Application Reference Number:	2026/0603
--------------------------------------	-----------

Application Type:	Permission in Principle
--------------------------	-------------------------

Proposal Description:	Permission in principle for residential development of up to 5 additional dwellings (6 dwellings in total, including retained Willow Cottage).
Location:	Willow Cottage, Carlton Road, Carlton, Barnsley, S71 3HX

Site Plan
1:200

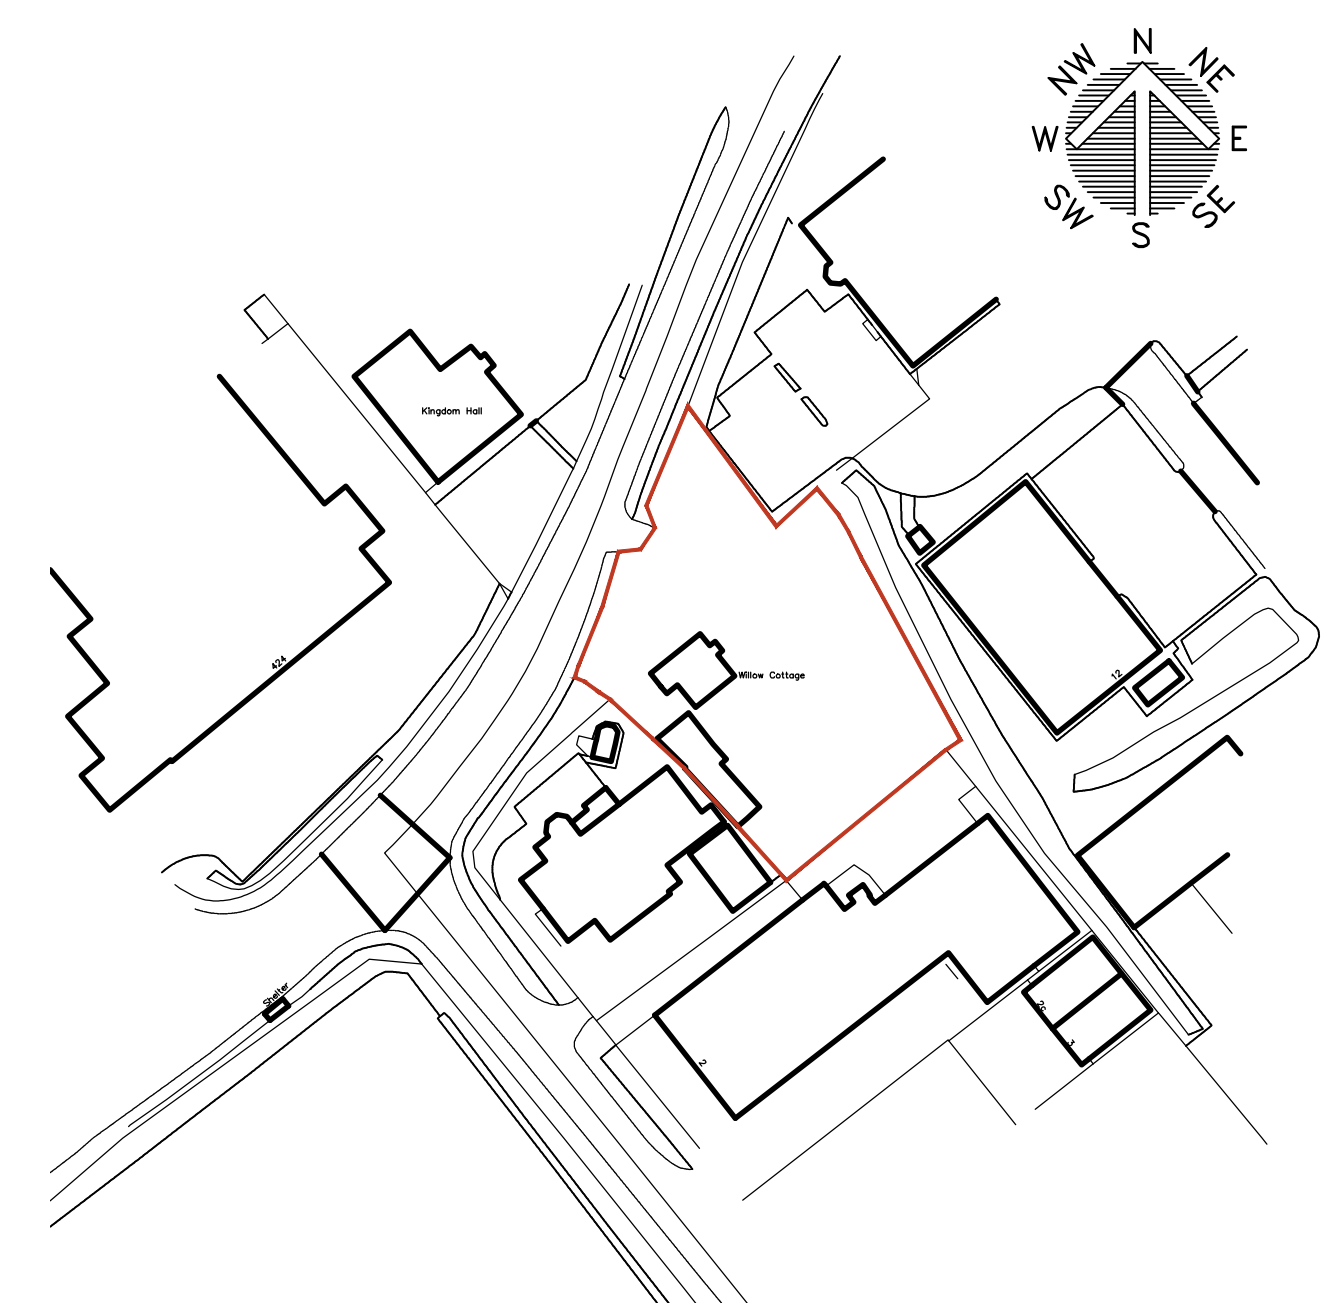
Highways DC – No objection at this stage. The application submission includes an indicative layout showing six dwellings being served by an existing access off Carlton Road. Some of the access will need to be put forward as adopted highway due to the number of dwellings exceeding 5. The section of drive/road which would serve plots 1, 2, and the existing dwelling would need to be adopted, with the road to plots 3-5 being able to remain as a private drive. Two visitor spaces are proposed which accords with the requirements of the adopted Parking SPD.

The layout will require some alterations when technical detail consent is sought to be acceptable from the perspective of highway development control. Informative attached on this basis.

The proposed development includes the erection of up to 5x dwellings in addition to the existing dwellinghouse which would be retained. The application submission includes an indicative site plan which demonstrates that 6 dwellings can be erected at the site and broadly achieve the required separation distances; space standards and suitable outdoor amenity space in accordance with the adopted SPDs.

The South Yorkshire Residential Design Guide Section 4.B.1.1.9 states that unadopted shared private drives may give access for up to a maximum of 5 dwellings. As mentioned in the Highways DC Officer comments (summarised above) due to the development creating an excess of 5 dwellings the entirety of the development cannot be served by a private drive. The subsequent technical details consent would therefore need to include full details of the adoptable section of road. Further advice regarding this is set out in the informative.
